HERTFORDSHIRE ECOLOGY

Application Reference: 6/2021/0474/COND

Proposed development at: 34 Vineyard Road Northaw EN6 4PA

Proposal: Submission of details pursuant to conditions 2 (landscape works) and 3 (biodiversity) on planning permission 6/2020/1365/FULL

Site Layout.
Proposed Landscaping.

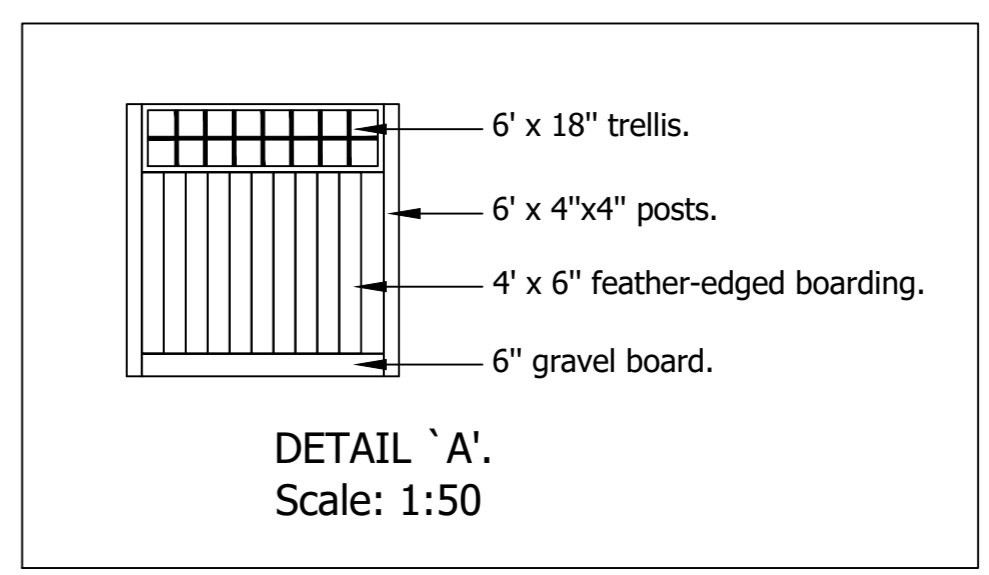
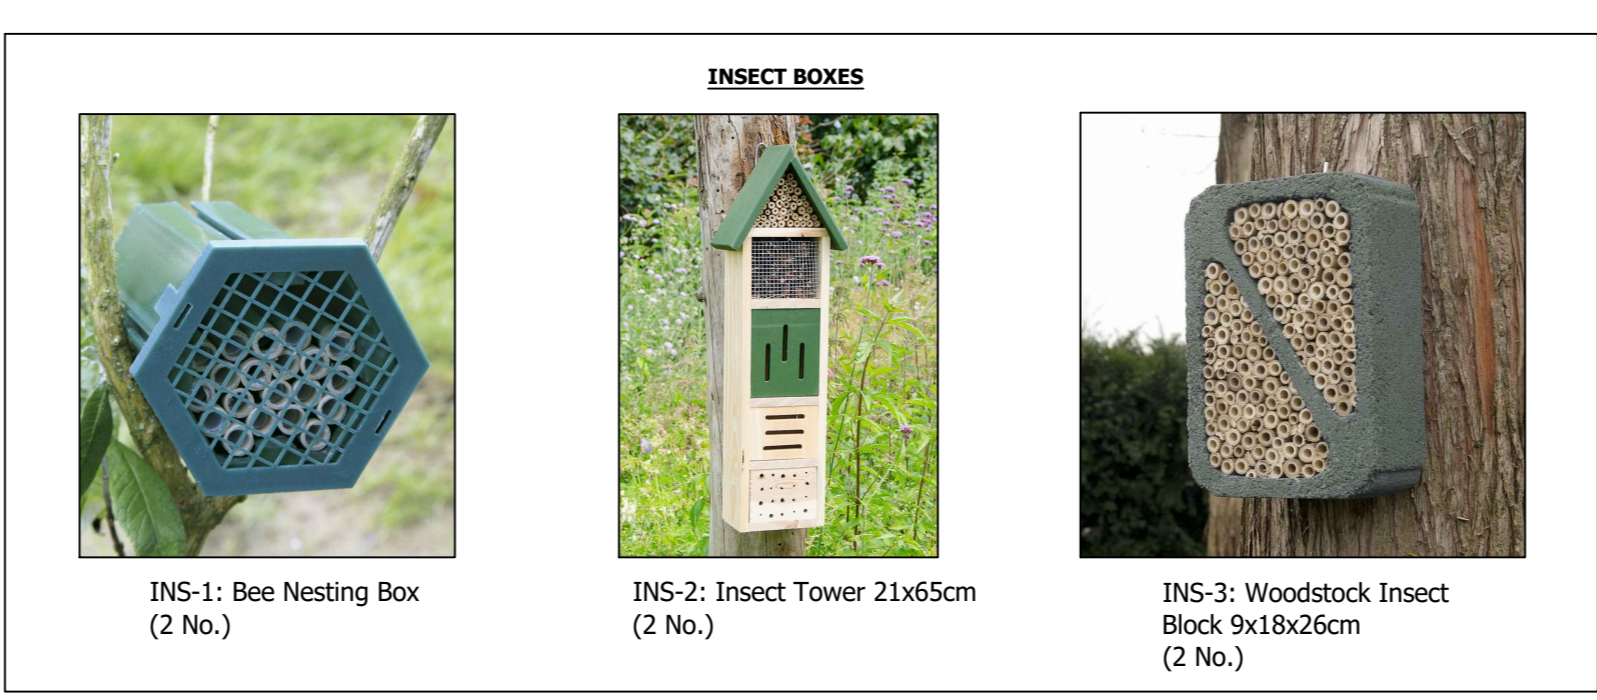
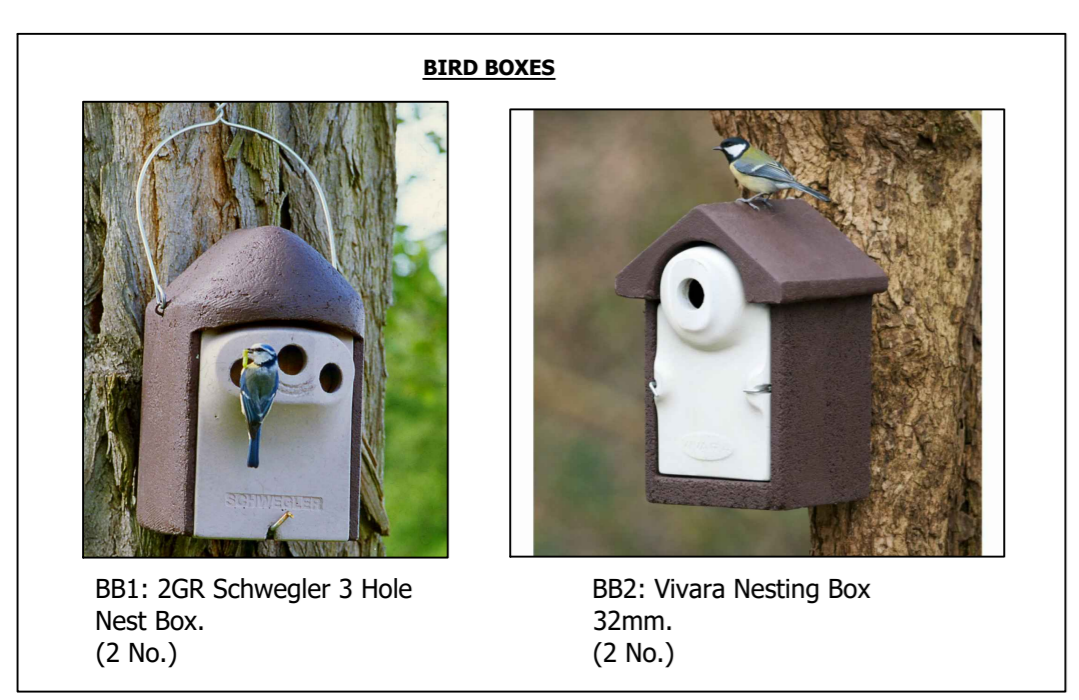
A Proposed Landscape Plan, January 2021, revised 19/04/2021 (Drawing Number: L2006/01, Rev A – with bat box note added to existing trees) by TDC Group has been submitted in support of this discharge application. This show the location and type of habitat boxes to be installed to increased biodiversity opportunities from the development. I am also please to see flowering plants, which will attract pollinators, are included in the planting scheme.

I consider condition 3 has been satisfied and am happy to advise it can be discharged.
